RE: Fwd:

I am writing with reference to the attached submissions (excluding some of the civil plans) that you sent earlier this month to address the conditions of the Planning Board's approval for this this project. My comments IN CAPS and are set in the context of the relevant condition:

ii. That the applicant shall prepare a revised Construction Management Plan to address the comments of the Traffic Engineering reviewer Tom Errico dated 3.16.2016, for review and approval by the Planning Authority; and

1 FLOOR PLAN - GARAGE/BASEMENT
 SCALE: 1/4" = 1'-0"

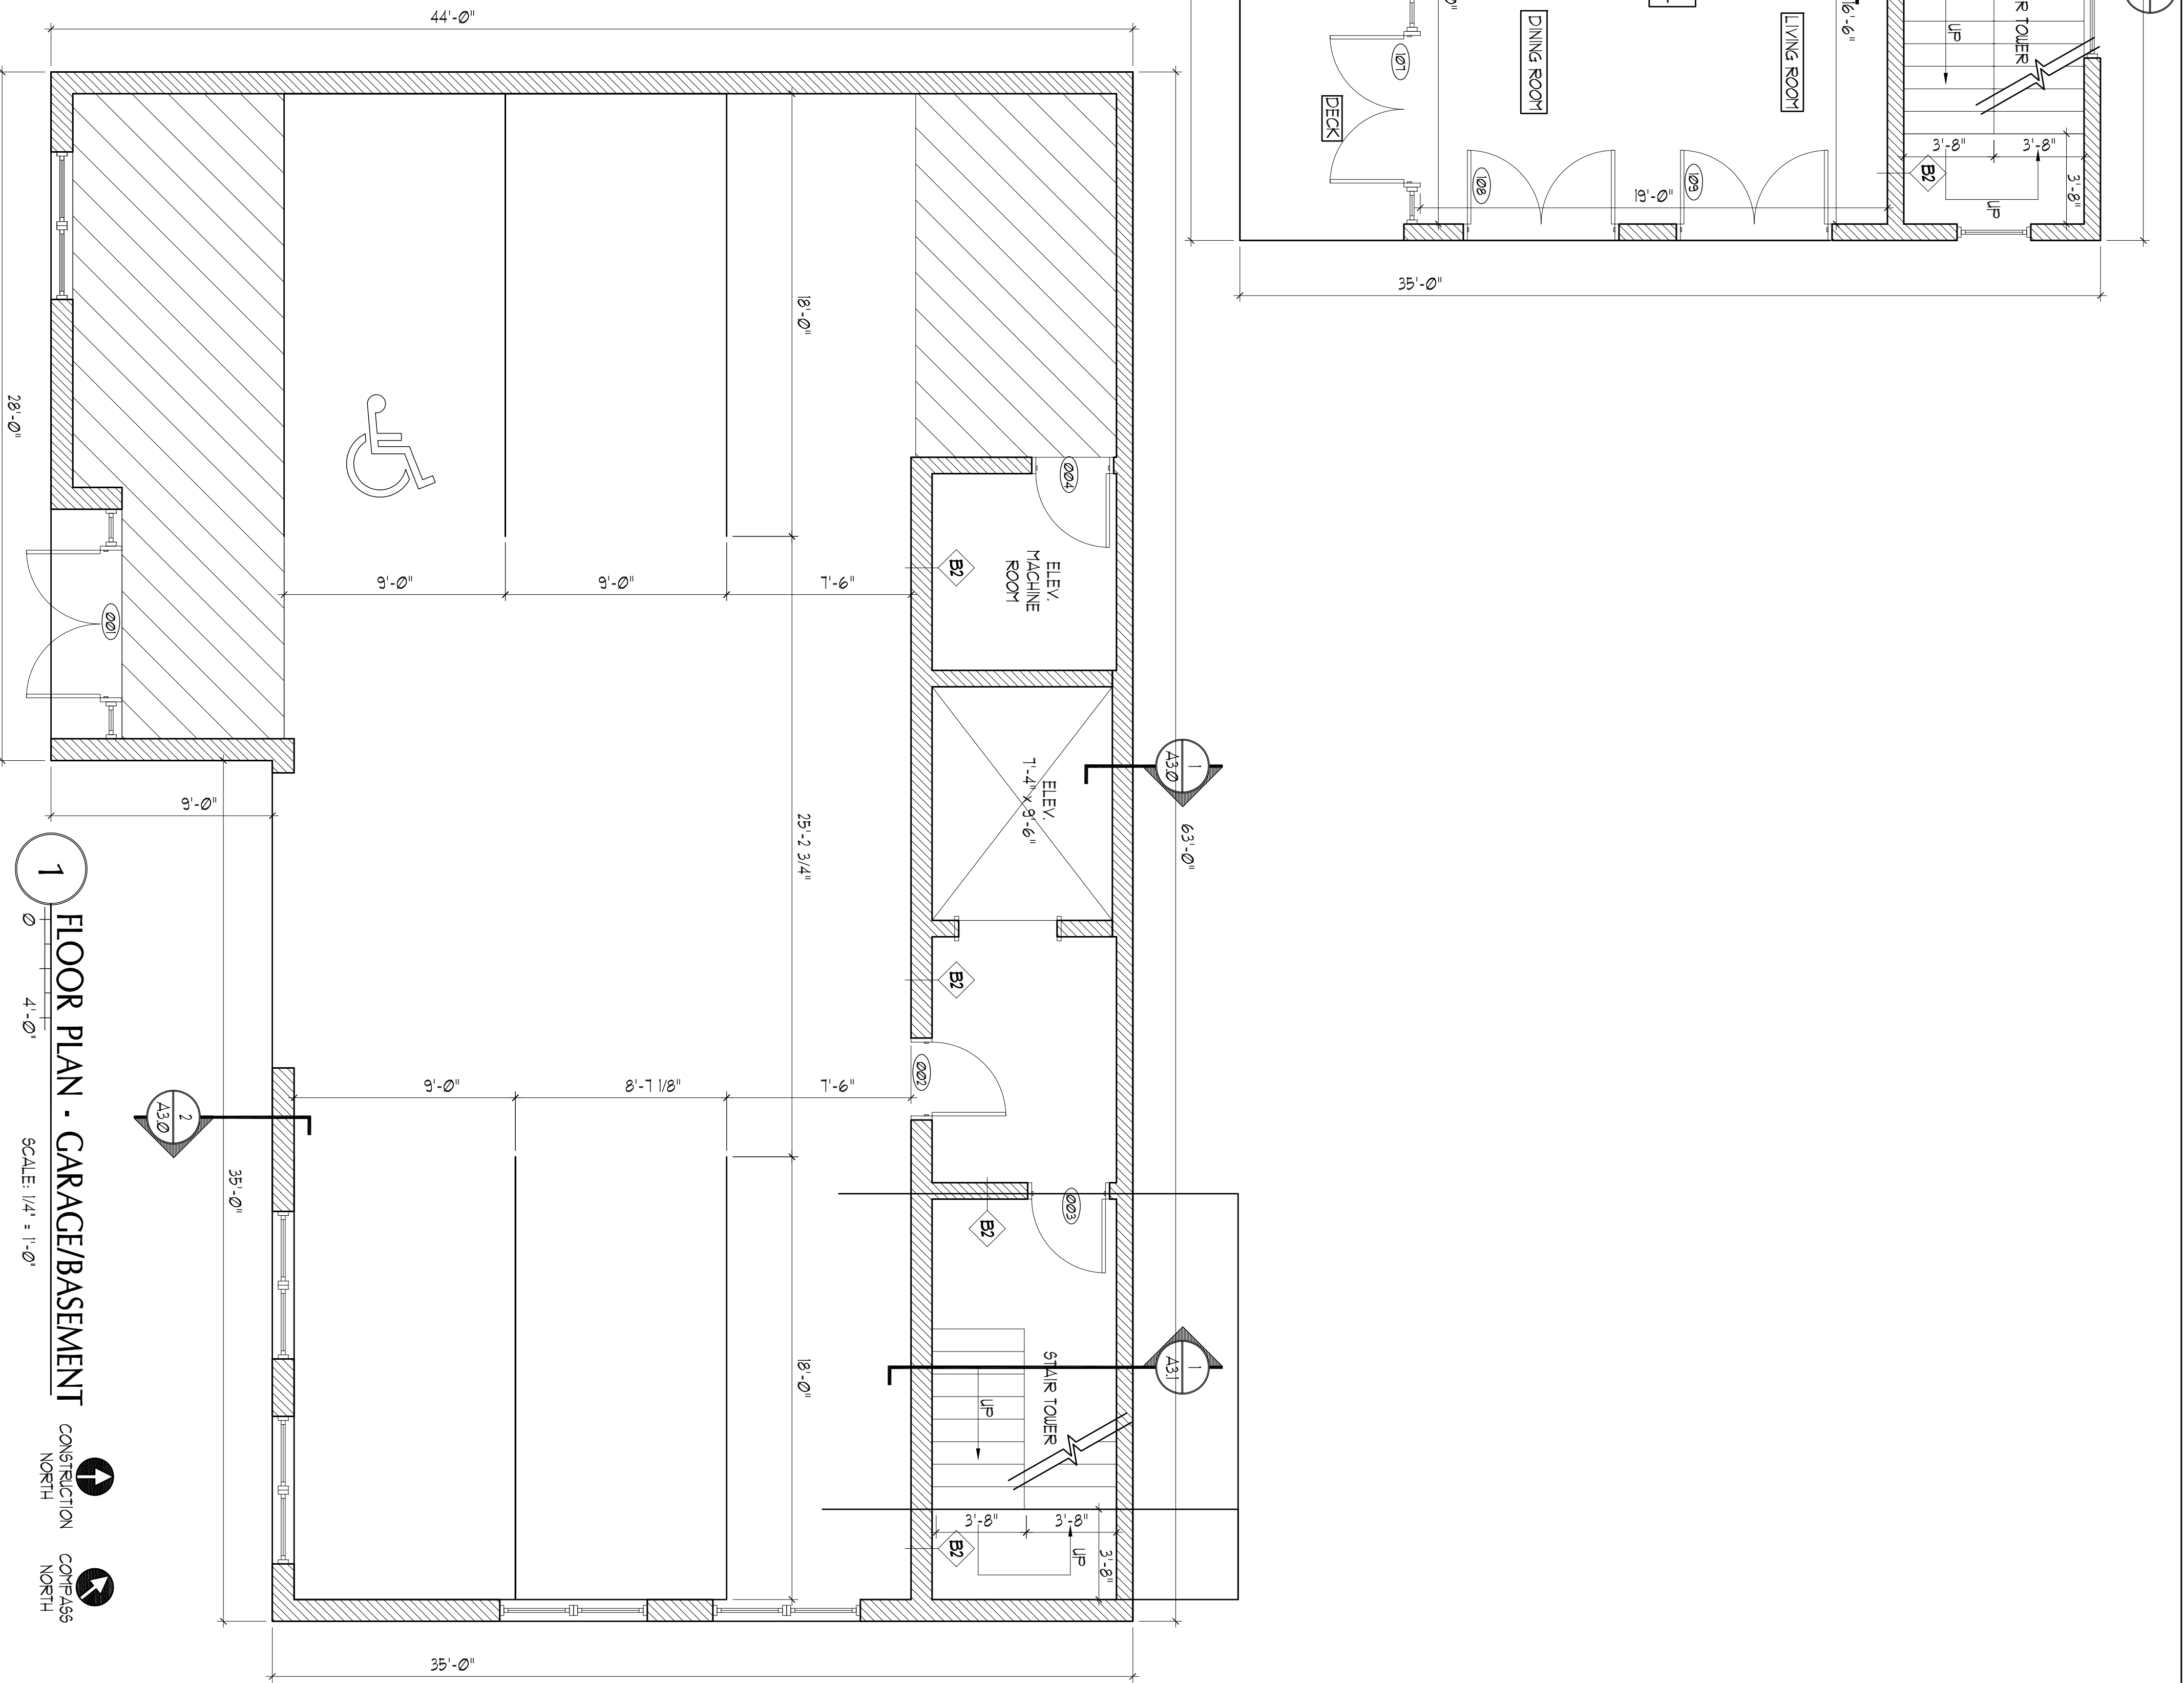
i. **That the applicant shall submit a revised parking layout within the parking garage to show an ADA compliant parking space, for review and approval by the Planning Authority prior to the issuance of a building permit. The applicant may convert up to 2 spaces to be less than standard size and may reduce the number of parking spaces to meet this requirement, subject to meeting zoning requirements and satisfying the Traffic Engineer regarding operation.**

PLEASE SEND THE FINAL SET OF FLOOR PLANS (INCLUDING THE GARAGE LEVEL TO MATCH THE SITE PLAN) WITH AN ARCHITECTS STAMP AND NOTE TO SHOW THAT THE ARCHITECT HAS CONFIRMED THESE MEET ADA REQUIREMENTS. [WE ARE NOT SURE THAT THE PARKING SPACE MEETS ADA BUT IF THE ARCHITECT CONSIDERS IT DOES THEN HIS STAMP WILL COVER THAT re the condition.]

DRAWING NAME: **SITE PLAN**
 PROJECT NAME: **31 FORE STREET REDEVELOPMENT**
 CLIENT: **PENINSULA PROPERTY DEVELOPMENT, LLC.**
 ADDRESS: 59 MOODY STREET, PORTLAND, MAINE 04101

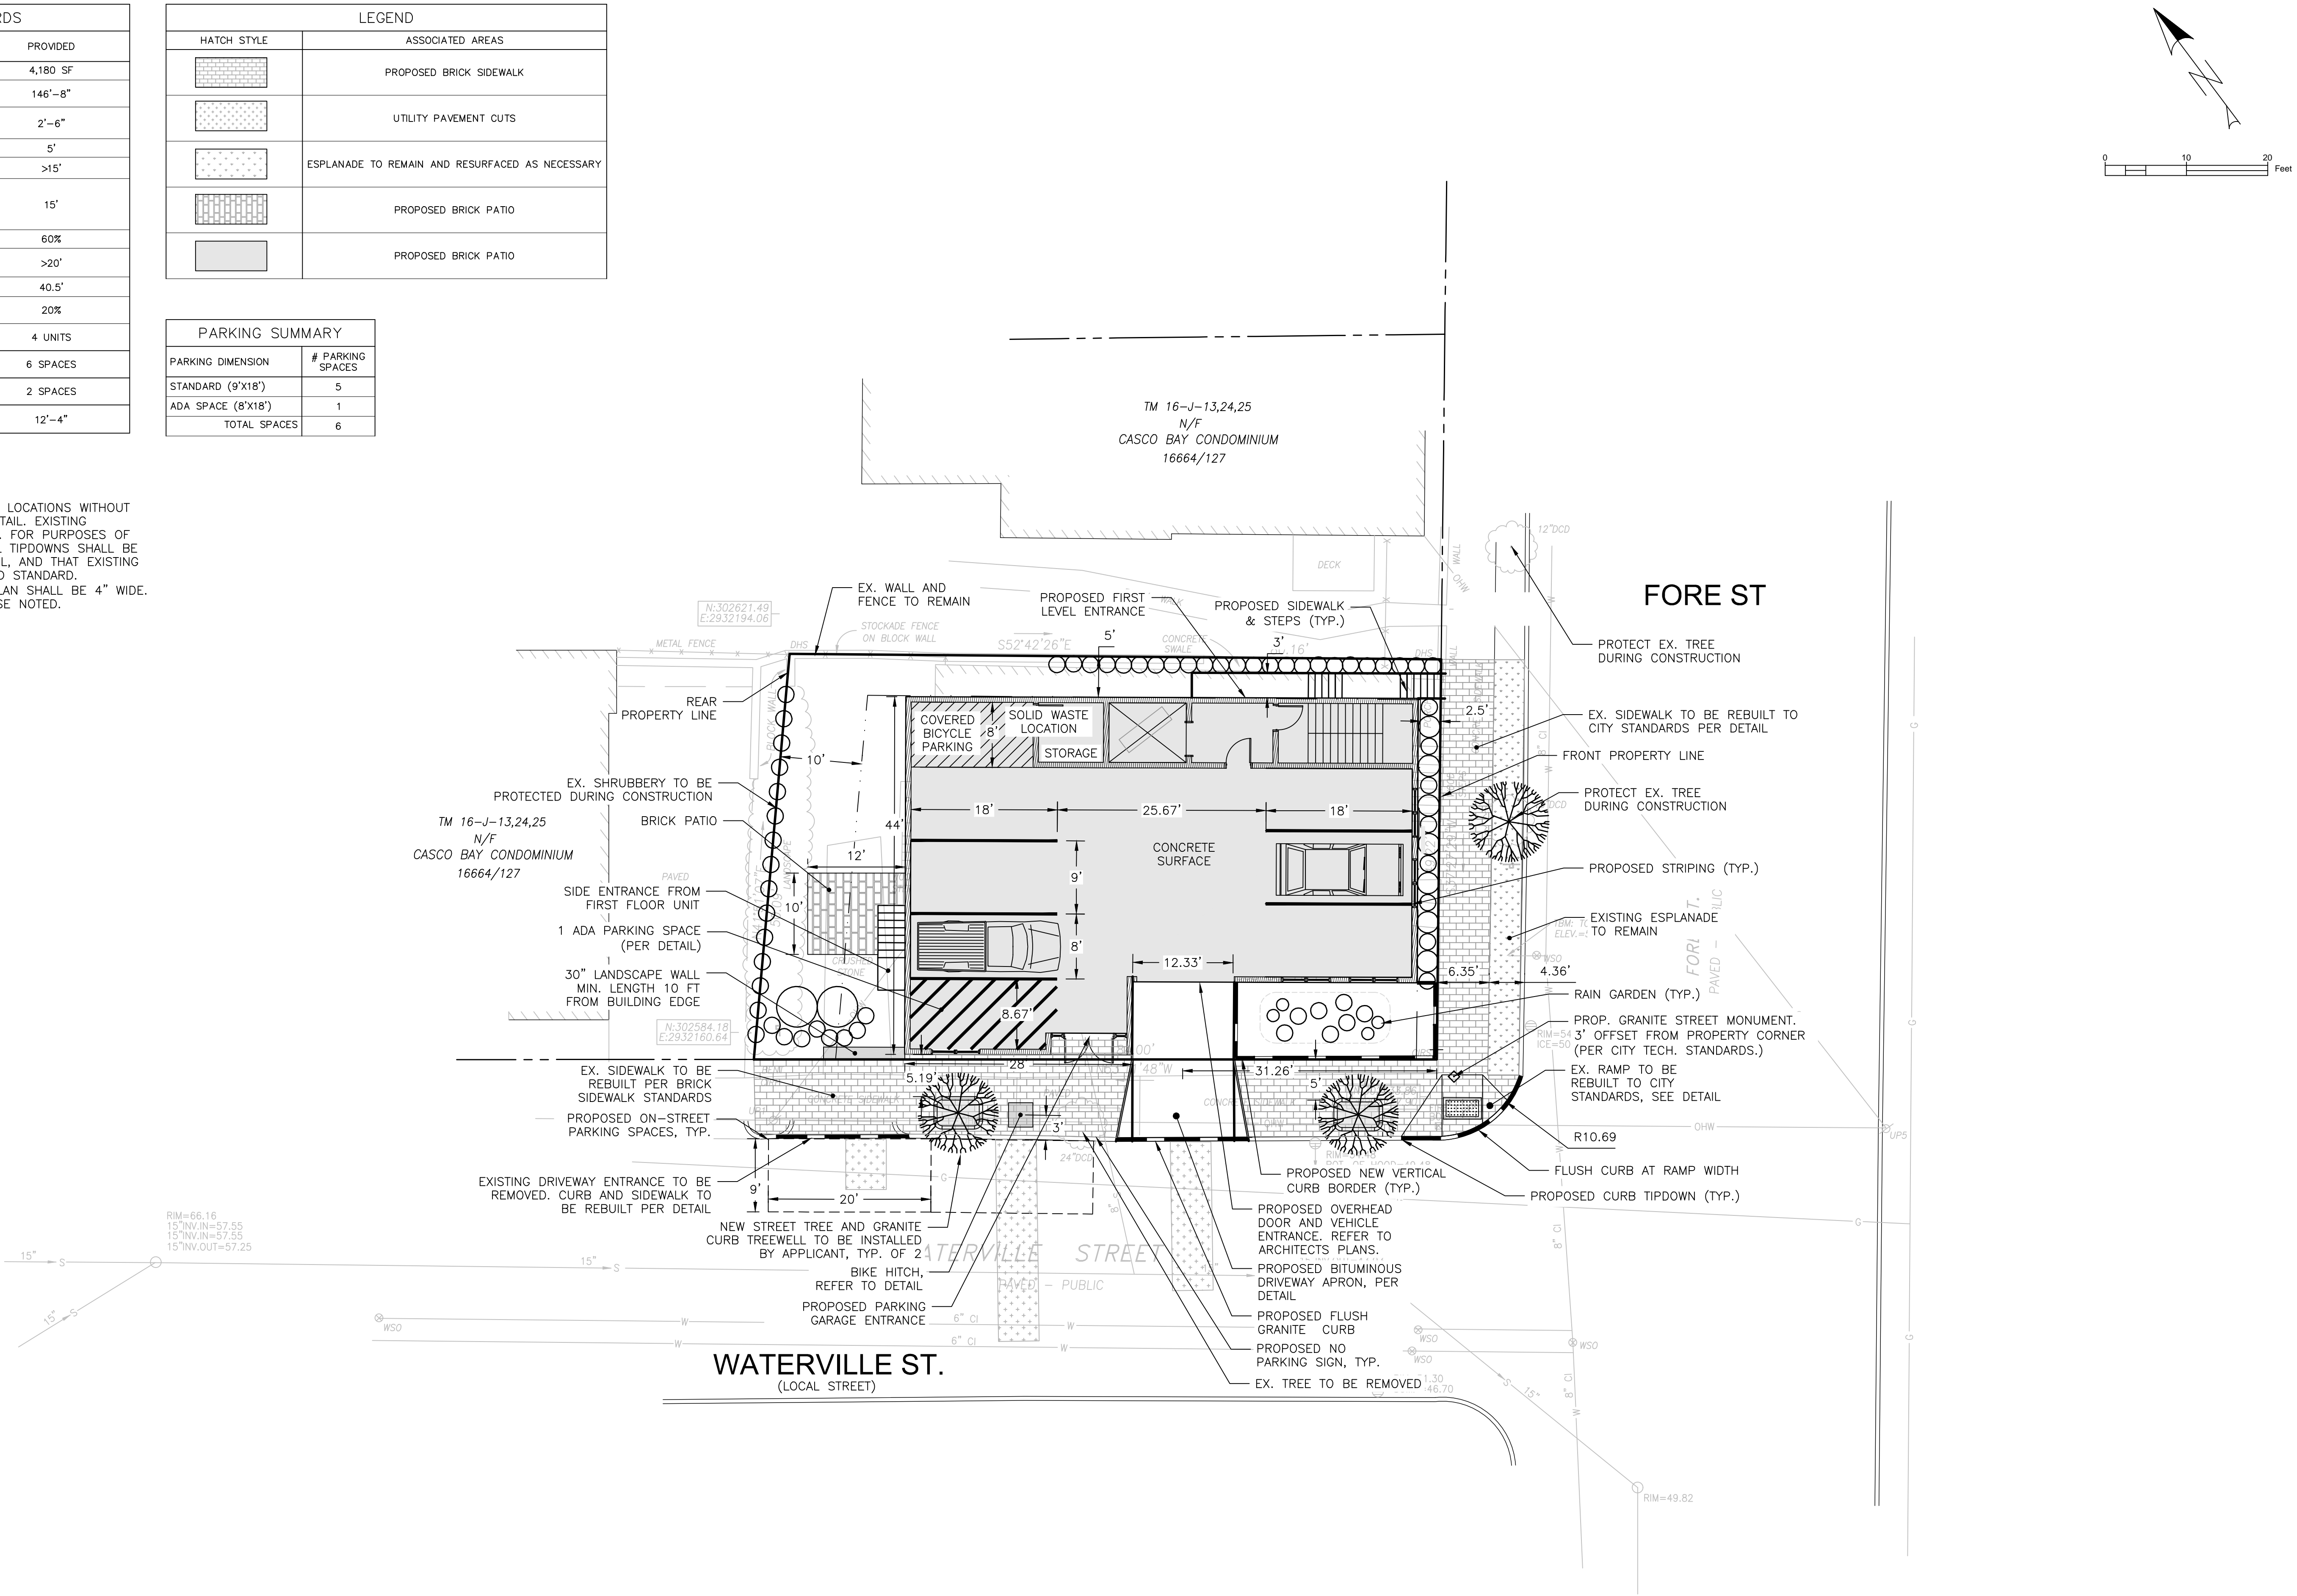
PLEASE ADVISE ME AS TO WHERE THE REQUESTED NOTE (SEE #5 FROM DAVID MARGOLIS-PINEO) HAS BEEN ADDED TO THE PLAN SET; WE NOTE THAT THE BACKFLOW PREVENTER HAS BEEN RELOCATED WITH A CONCRETE COLLAR, BUT STILL APPEARS TO BE IN THE ROW (AND THE NOTE REFERS TO IT BEING IN THE ROW) AND I DO NOT HAVE A DPW SIGN OFF RE THAT..

- With regards to comment i.a. below please refer to the attached revised Utility Plan. The plan clarifies the location of the backflow preventer in note (note 5) and plan form. The final comment from David was within the General Notes #10 of the plan.
